File reference	TR020002
Status	Final
Author	The Planning Inspectorate
Date	2 November 2017
Meeting with	RiverOak Strategic Partners (RSP)
Venue	Temple Quay House
Attendees	The Planning Inspectorate Gareth Leigh – Infrastructure Planning Lead Richard Hunt – Senior EIA and Land Rights Advisor Nicola Mathiason – Lawyer Richard Price – Case Manager Louise Evans - Case Officer The Applicant Angus Walker (BDB Law) Alex Hallatt (BDB Law) Tony Freudmann (RSP) Niall Lawlor (RSP) George Yerrall (RSP) Rob Grinnell (RSP) Angela Schembri (RSP) Colin Smith (CBRE)
Meeting objectives	Review of the Planning Inspectorate’s comments on the draft application documents
Circulation	All

Manston Airport

Draft documents review

The following tables comprise the comments made by the Planning Inspectorate about the form and content of the suite of draft application documents offered by the Applicant (RiverOak Strategic Partners Ltd) in October 2017.

MANSTON AIRPORT DEVELOPMENT CONSENT ORDER
KEY PLAN TO ACCESS AND RIGHTS OF WAY PLANS SHEET 1 OF 1
REGULATION 5(4)
THANET DISTRICT COUNCIL

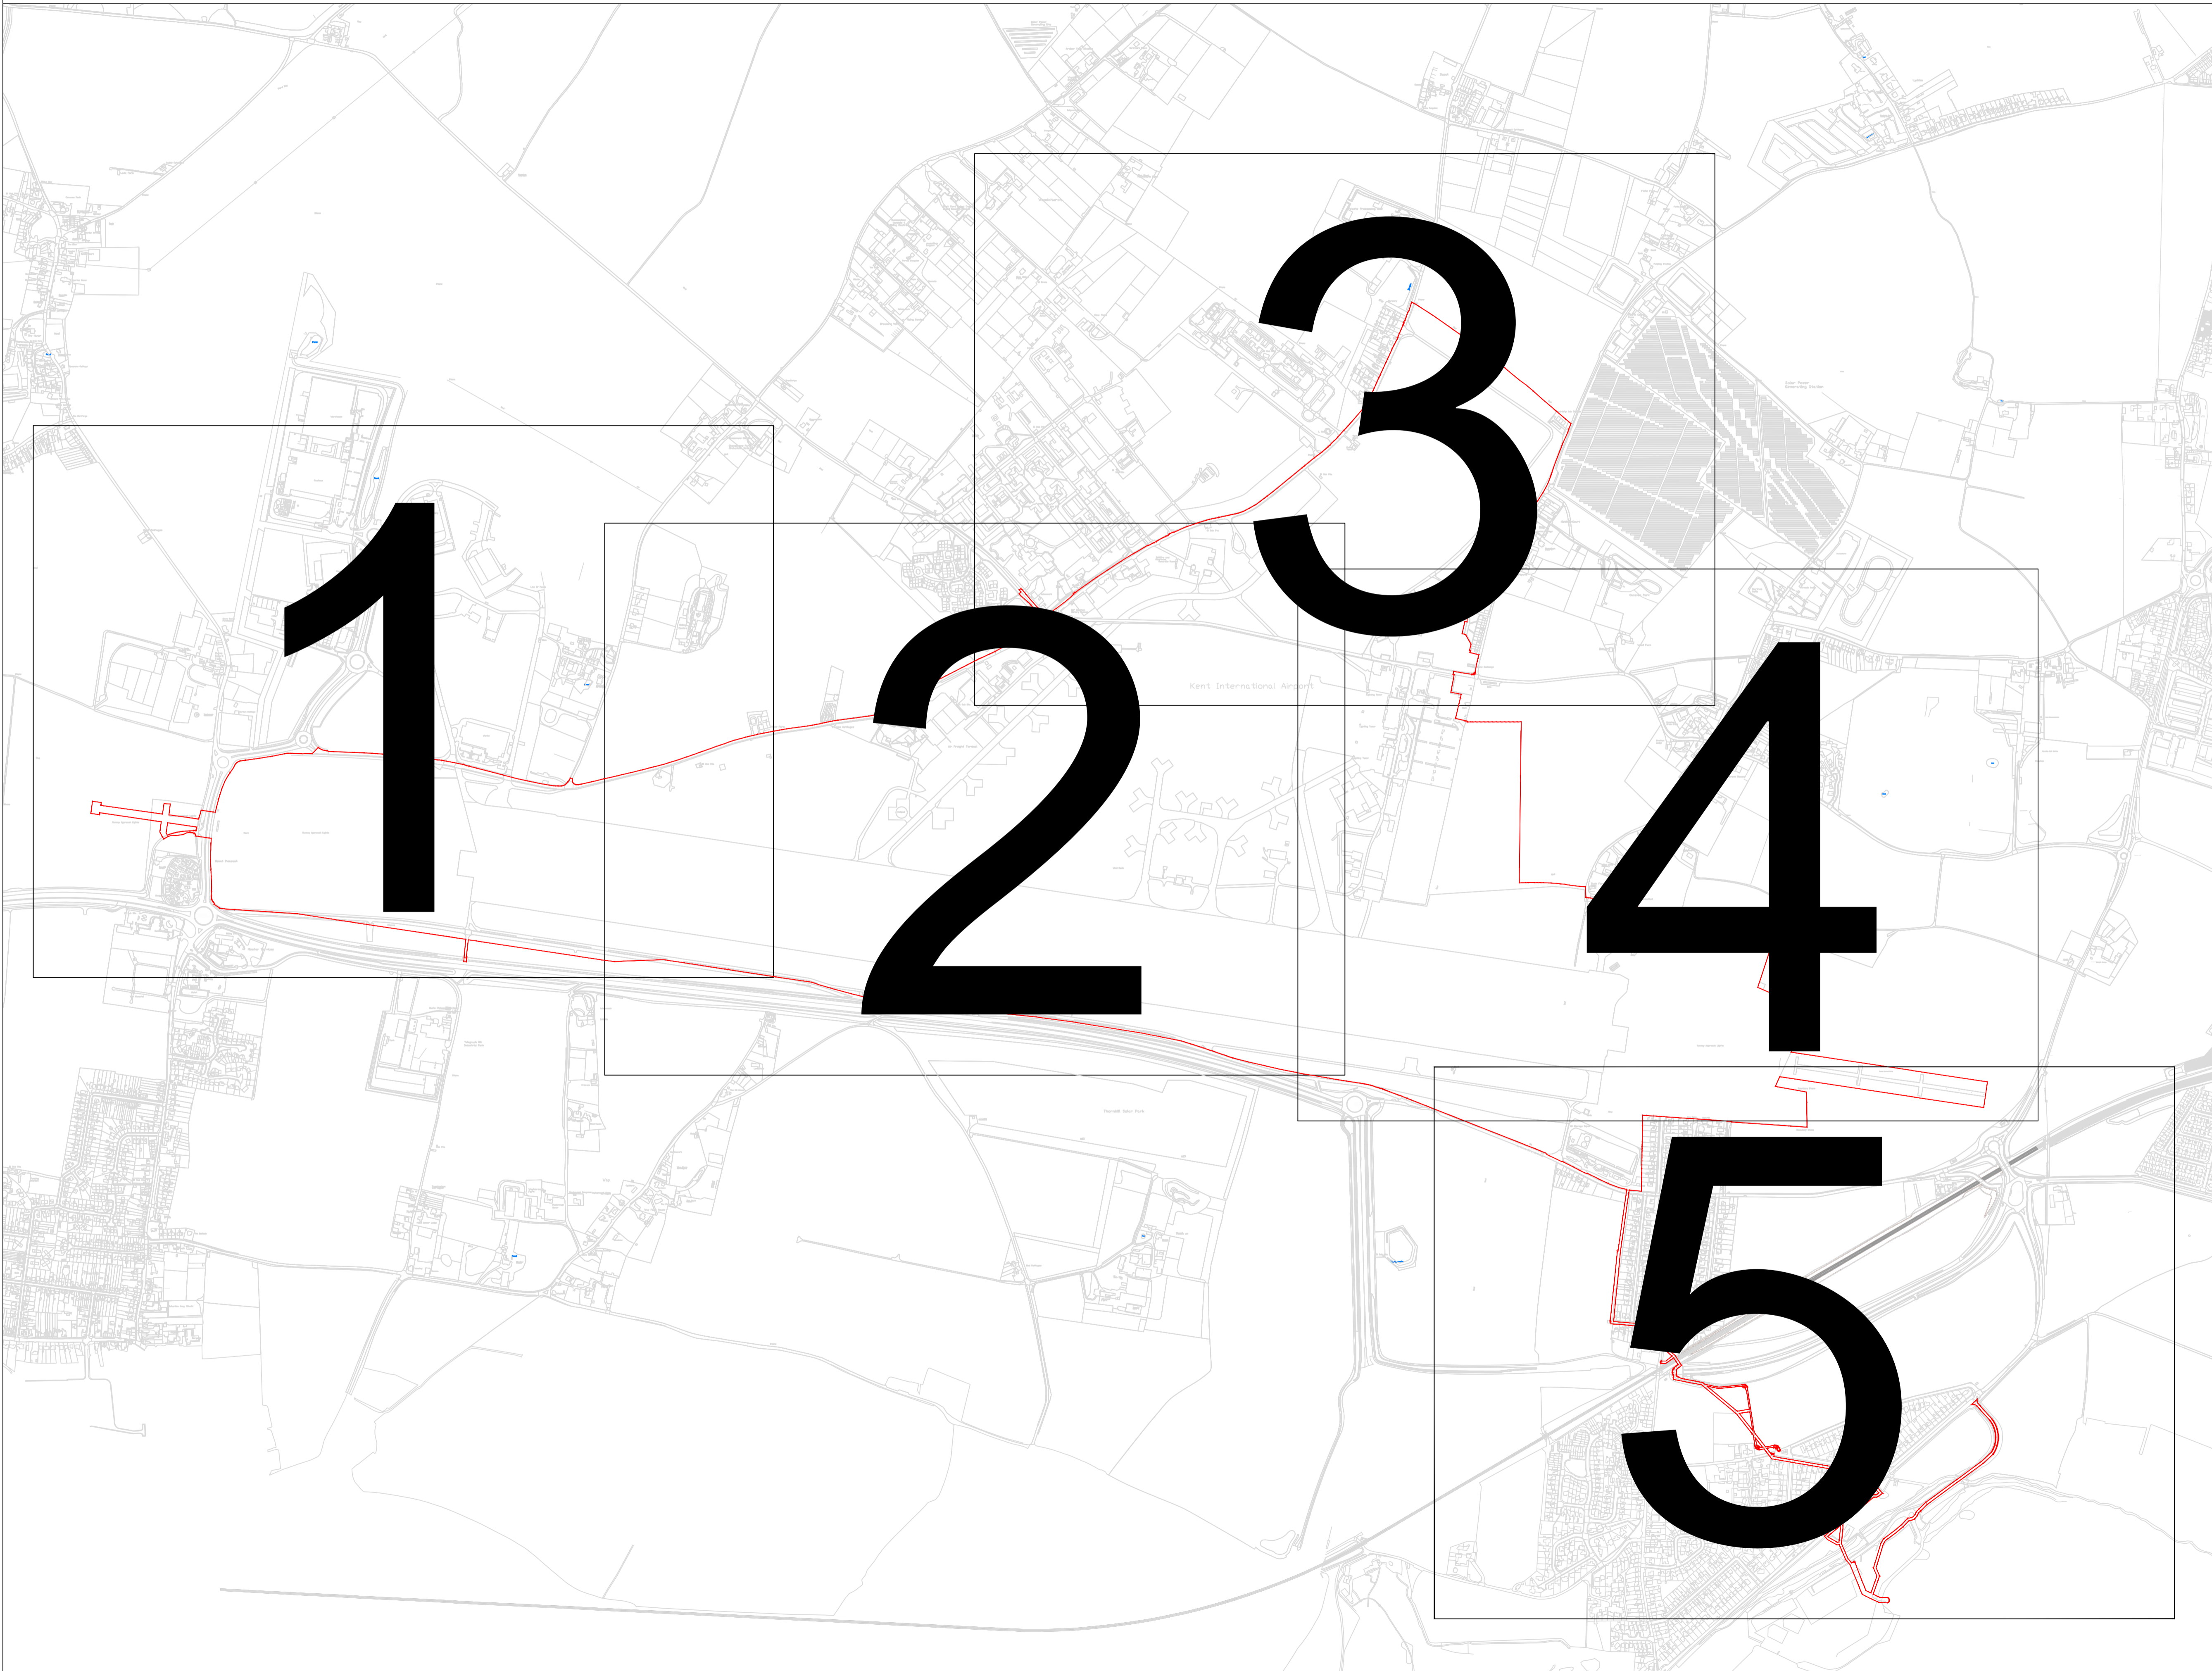
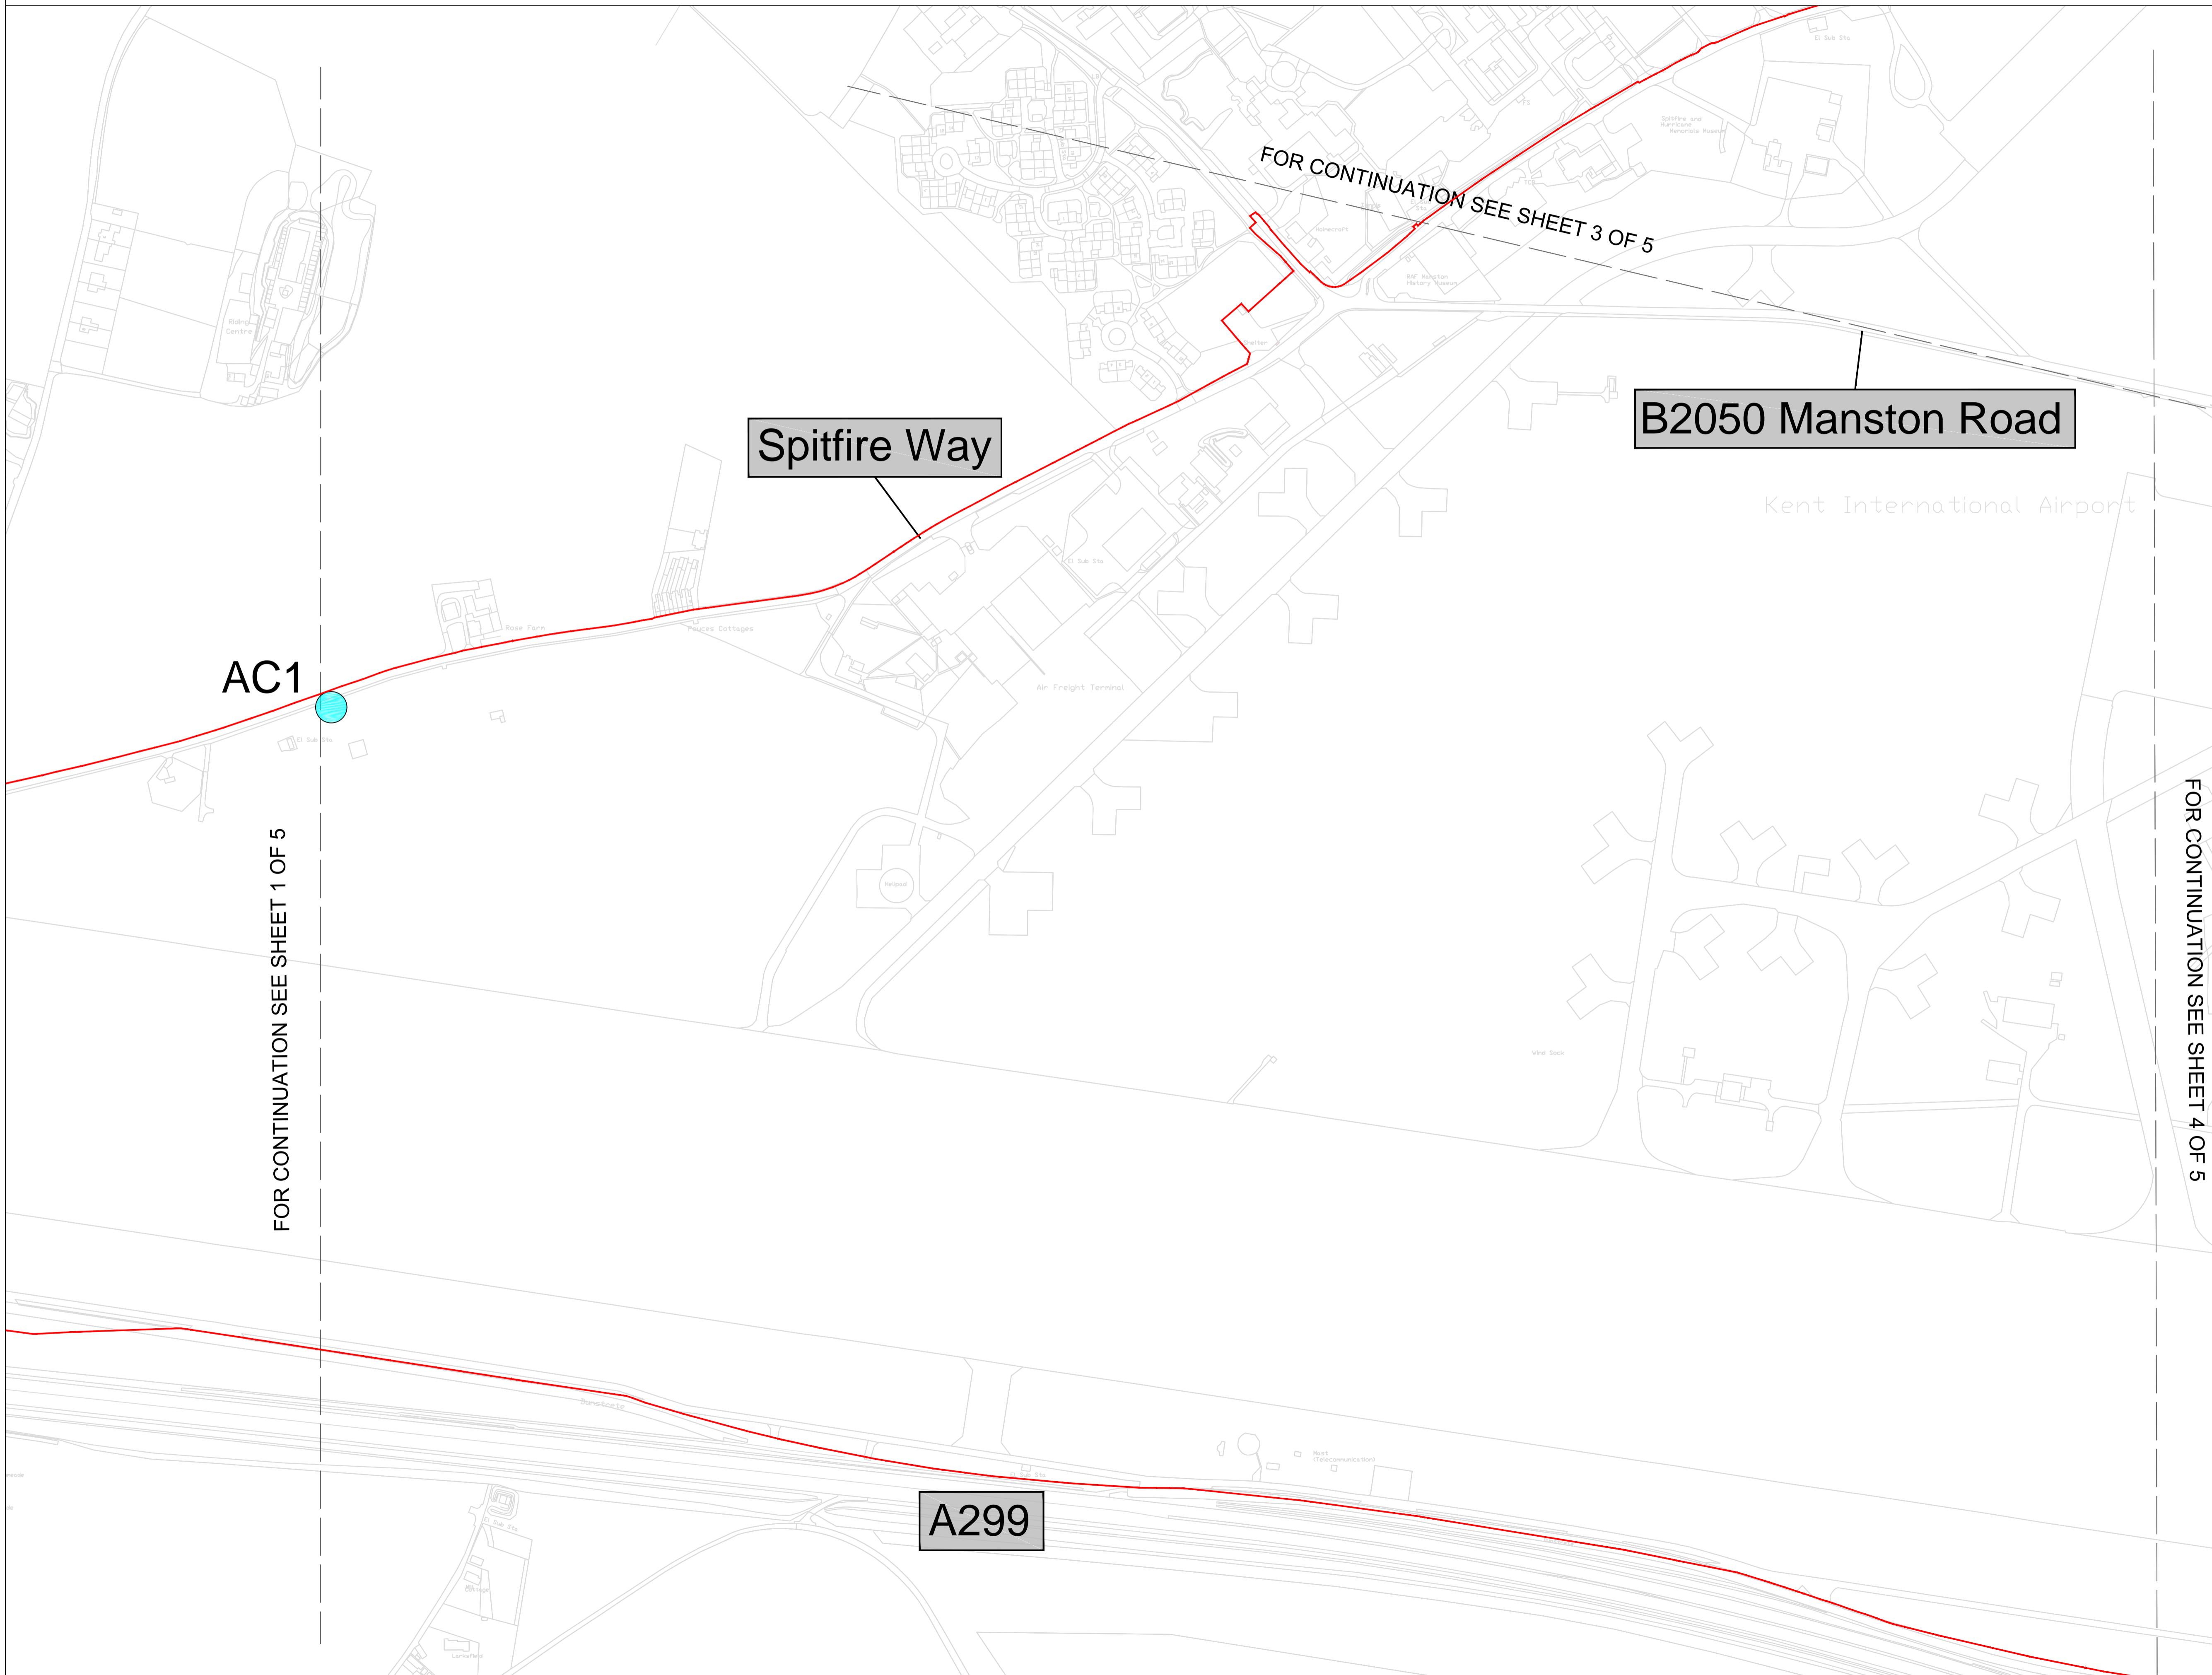
Article 10	<p>A10(1): These streets referred to should be identified on the streets, rights of way and access plan at Schedule 9</p>

and words included in this article that reference that plan; similarly with the diverted/ altered streets.
Article 11	Could the streets referred to be listed in a Schedule?
Article 13	The words " <i>with the consent of the relevant planning authority and after consultation with the highway authority</i> " should be included.
Article 14	A14(1): This should state it is for the purposes of the construction of the authorised development. A14(2): Explanation and justification needed for this. A14(5): Further explanation about implications of this needed to assist Examining Authority. A14(6): Justification for this wording needed as the usual wording included in this article is " <i>at any time prior to the part of the authorised development to which it relates being brought into operational use</i> ".
Article 15	A15(6): This provision prevents the discharge of gravel, soil, other solid substances, oil or matter in suspension. It makes no reference to matter in solution, which given that antifreeze is the main chemical discharge is a potential gap. However, the provision does make reference to Environmental Permit requirements which are likely to address this. It also makes reference to 'reasonably practicable' twice. A15(8)(b): Should the reference to the Water Resources Act 1991 be replaced by a reference to the Environmental Permitting (England and Wales) Regulations 2016?
